From: Amanda Scholes on behalf of Planning.Responses
Sent: 06 December 2017 08:27
To: Planning Scanning
Subject: FW: LU/121/17/RES - parcel C2 and part C1, B2 and B4 - email 4 of 4

From: Tim Townsend [<mailto:tim.townsend@westsussex.gov.uk>]
Sent: 05 December 2017 09:48
To: Michael Eastham
Subject: RE: LU/121/17/RES - parcel C2 and part C1, B2 and B4 - email 4 of 4

Please could I have your comments on the revised landscaping plans that were submitted by Laura Graham yesterday?

Tree Planting Details LA108

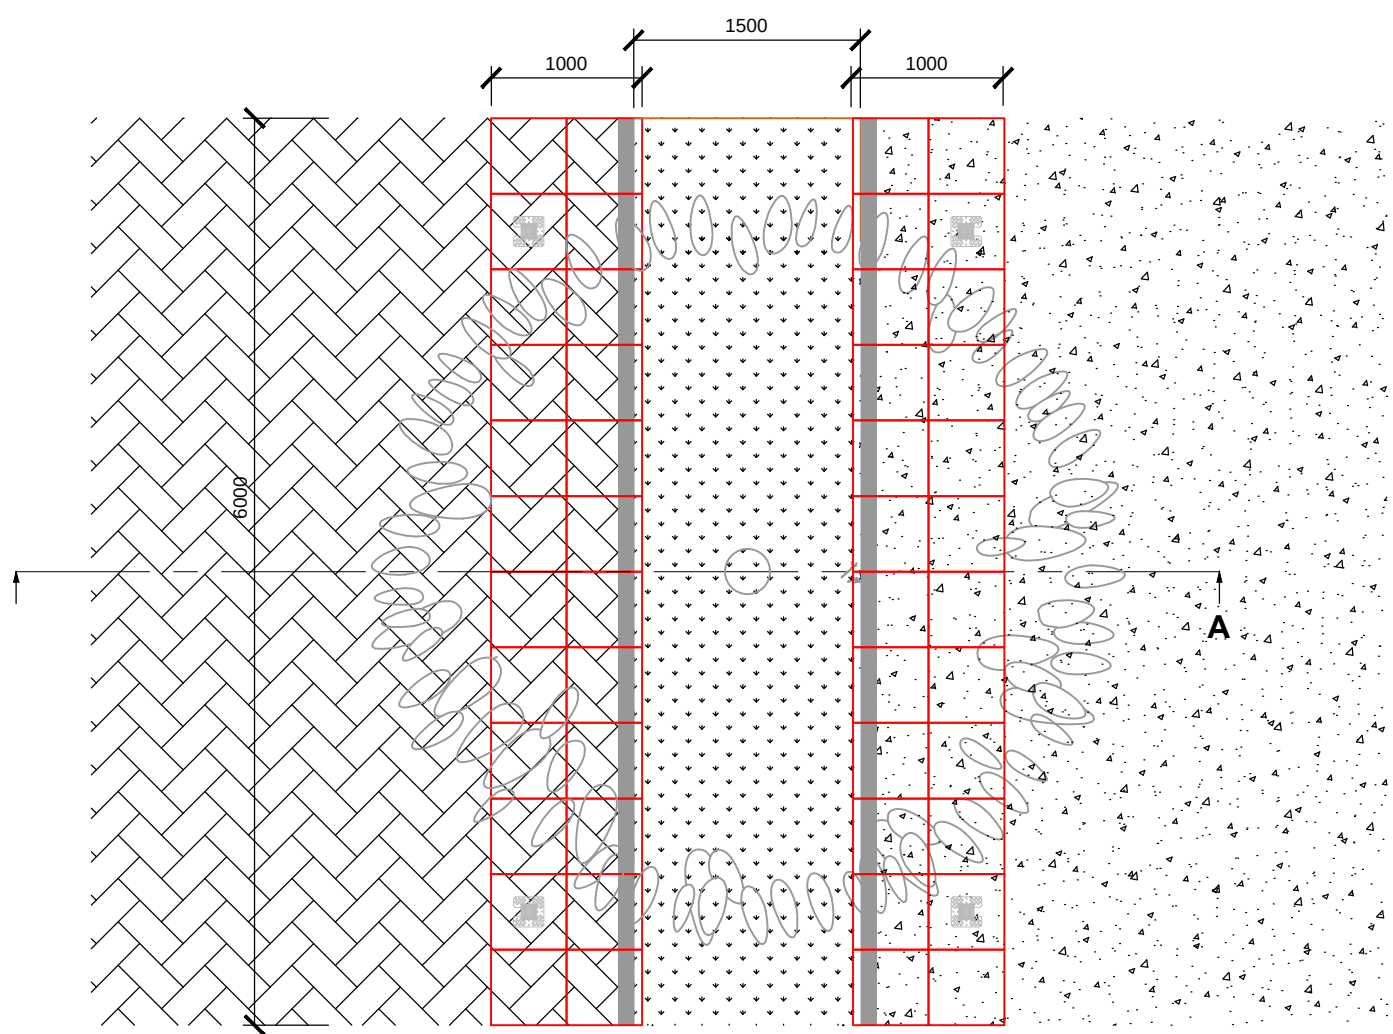
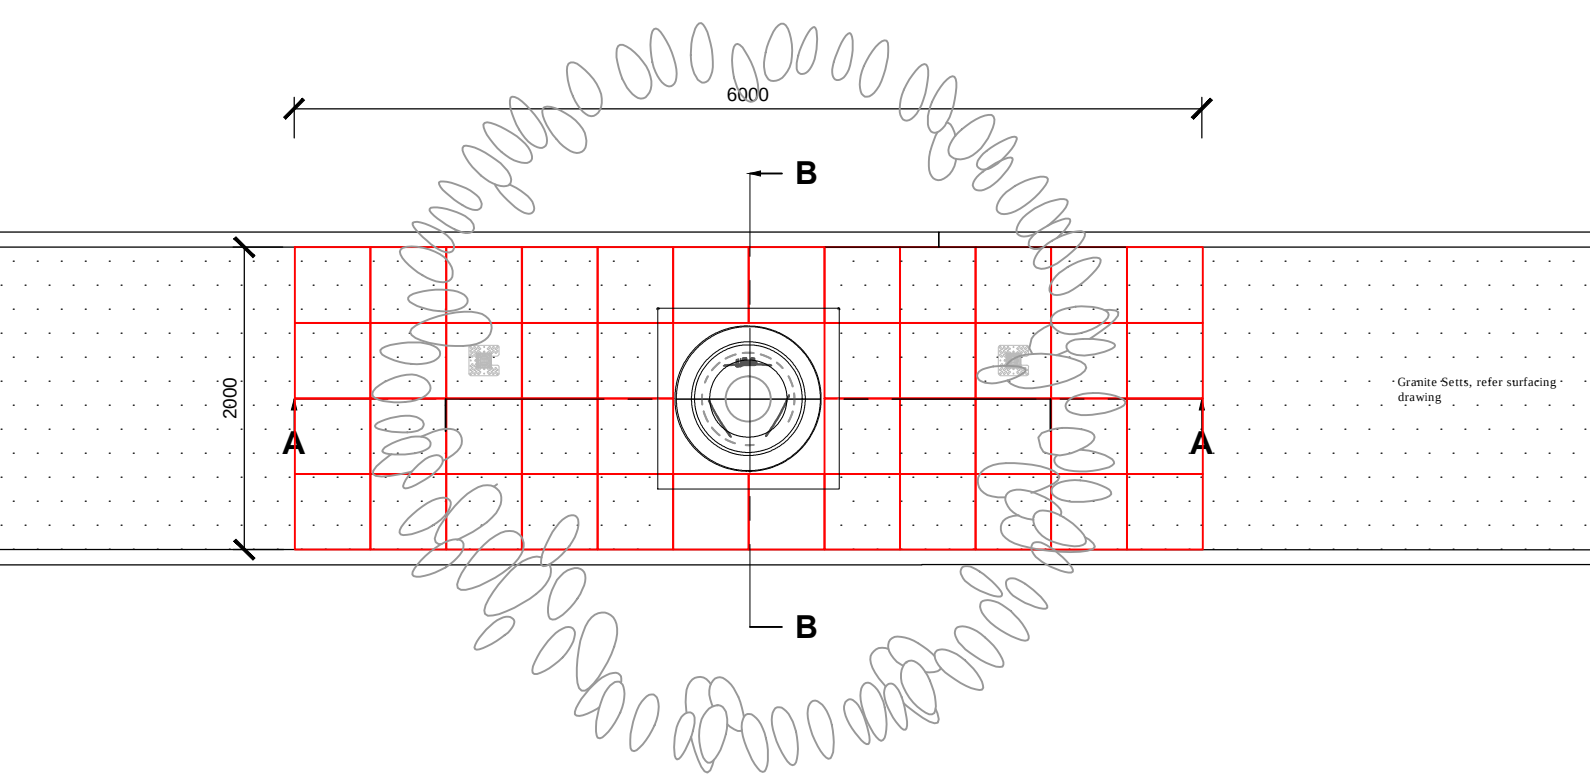
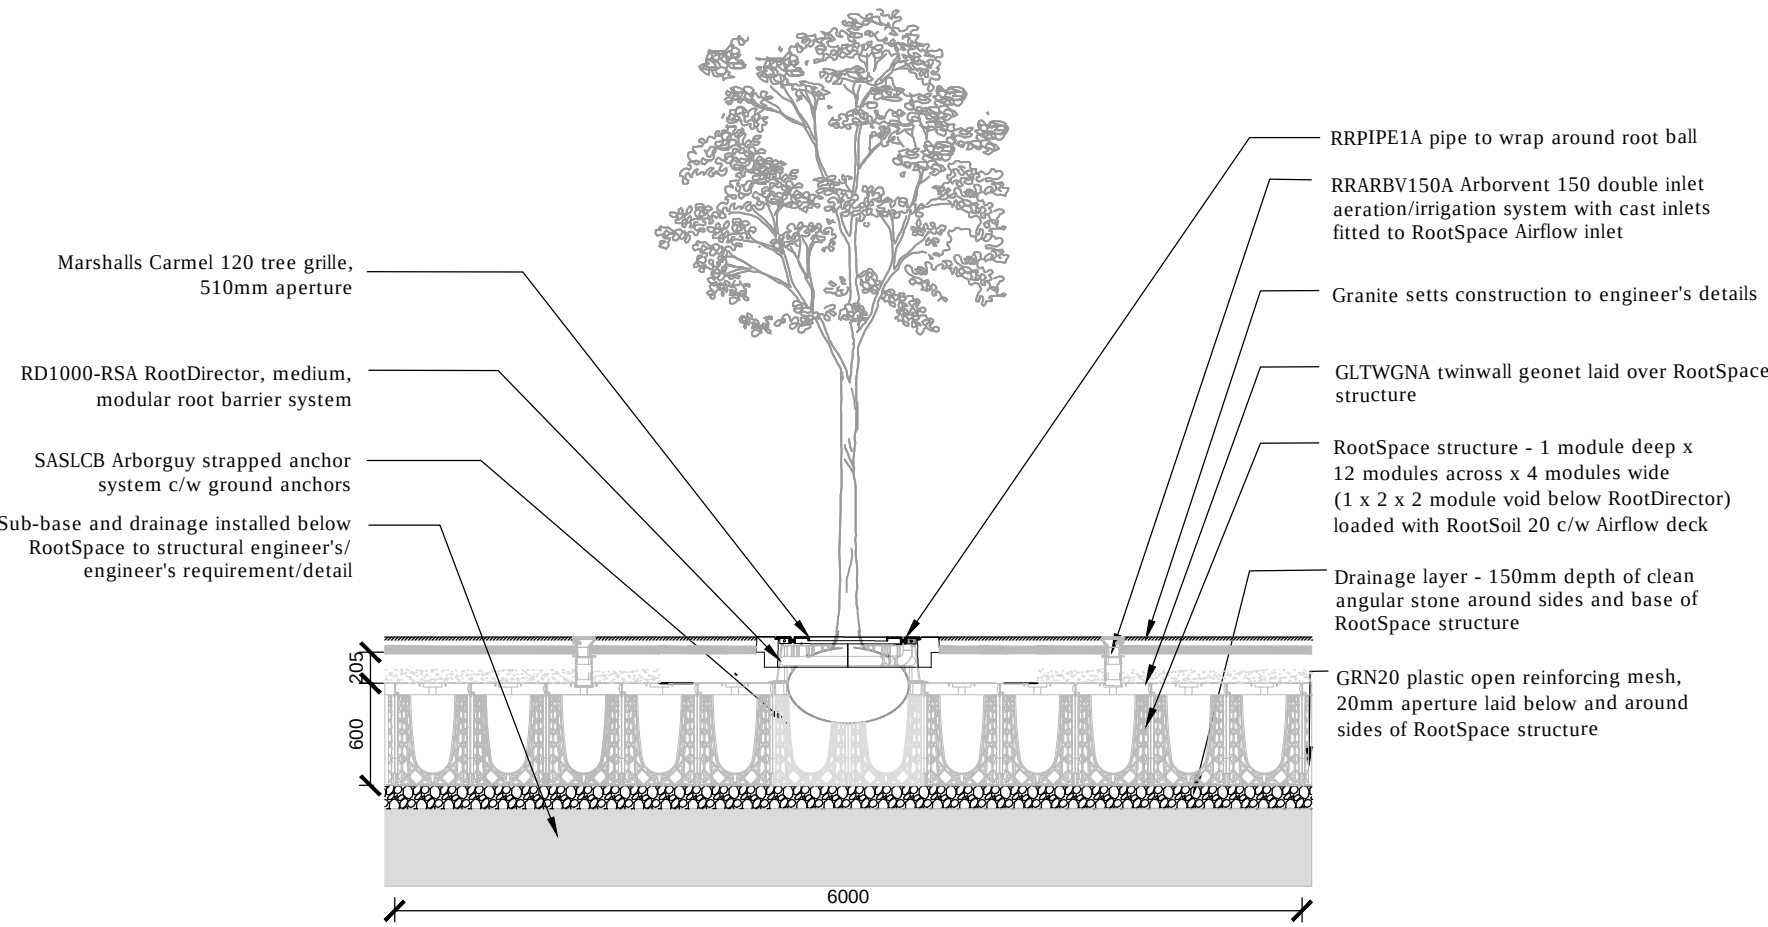
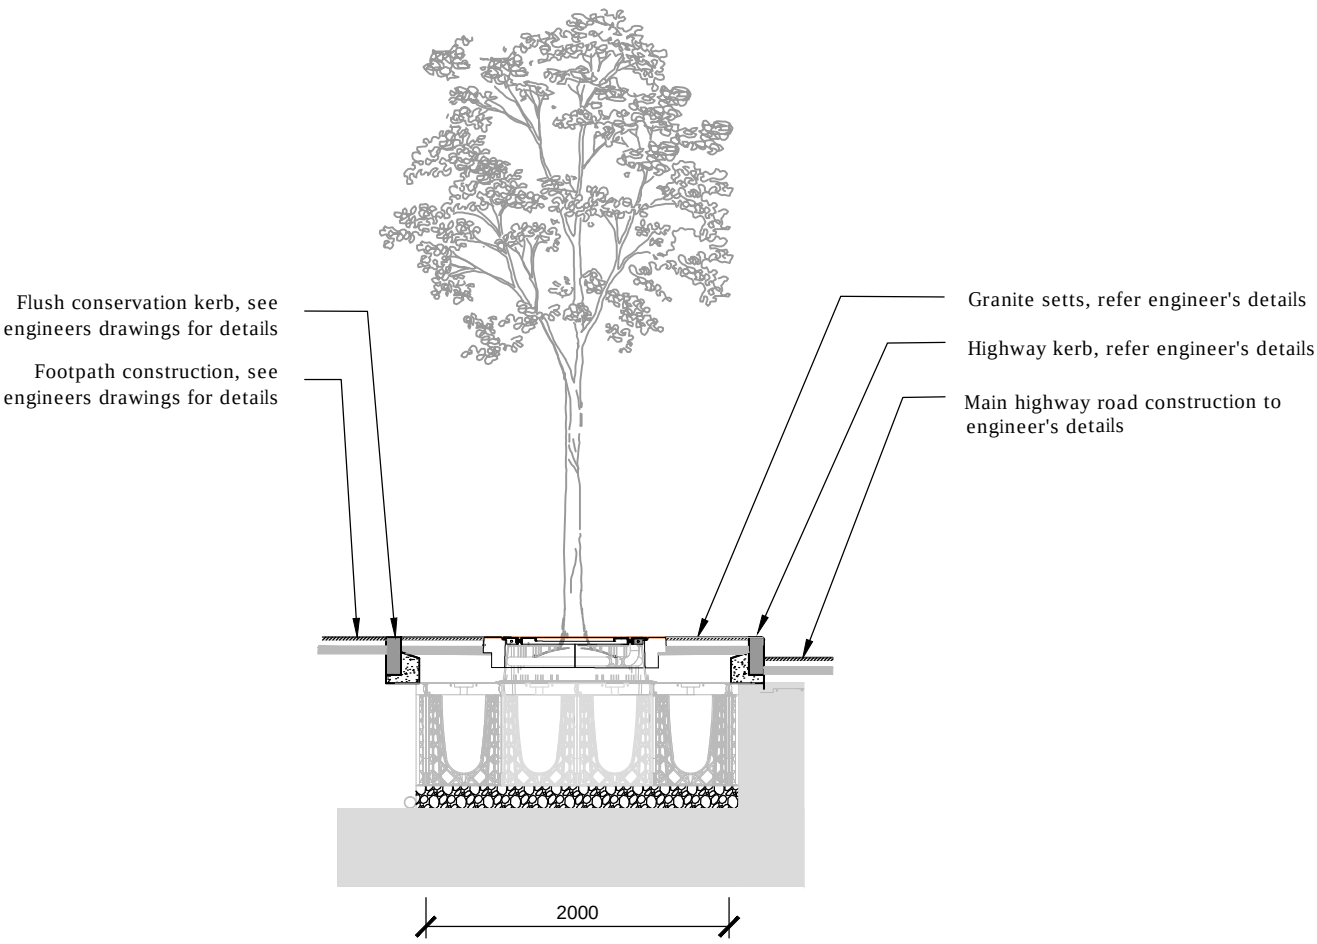
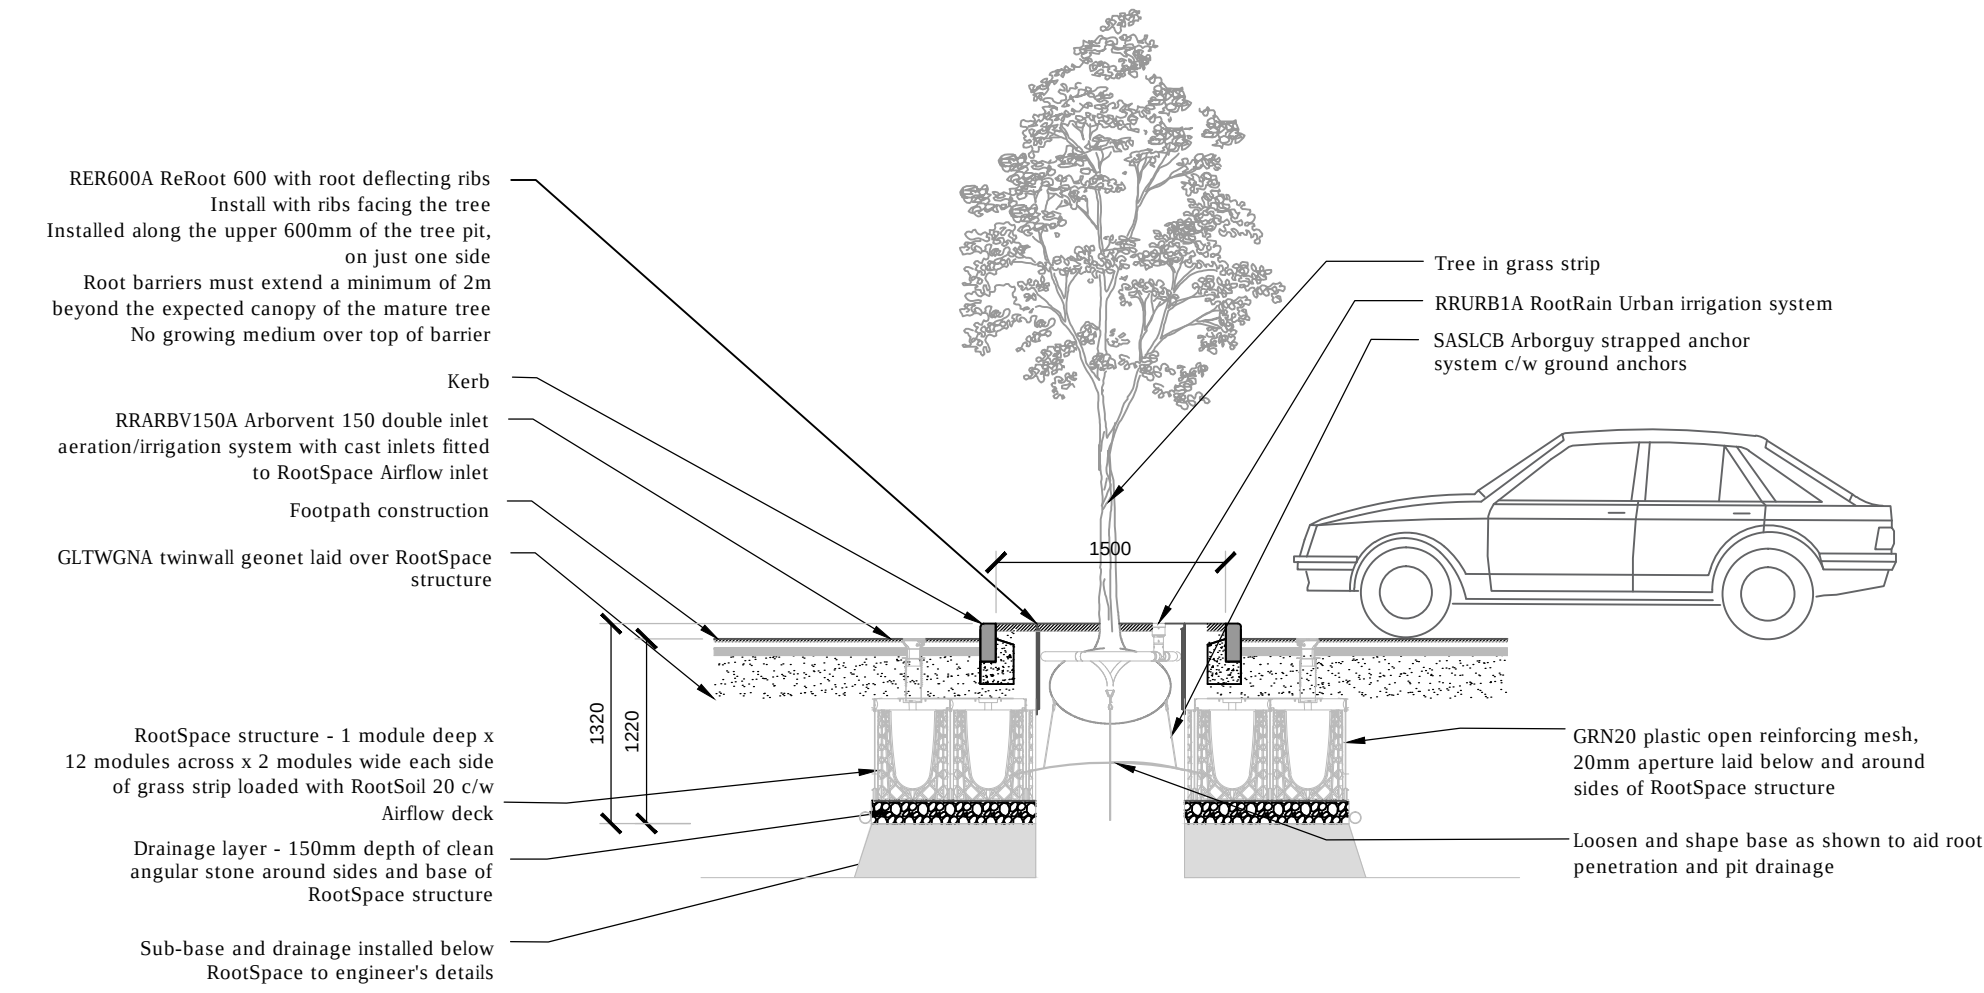
The key issue from a highway safety perspective is one of visibility and any impact the presence of trees might have on this. Although visibility splays have been shown on one of the plans, it appears to me that the pedestrian crossing points on the first section of main spine road (so the E-W section coming-in off the IDR) have trees too close to the crossing points which will mask pedestrians from drivers and vice-versa. We'd need to see clearer plans and ones showing that trees are not located as close to these crossing points. Furthermore, the 'knobbly' hard landscaping alongside the tree pits is not welcomed and presents a trip hazard to pedestrians.

When preparing revised plans, the applicant should also send them to their Road Safety Audit team for comment – the latter to be provided to both the LPA and CHA when anything new is made available.
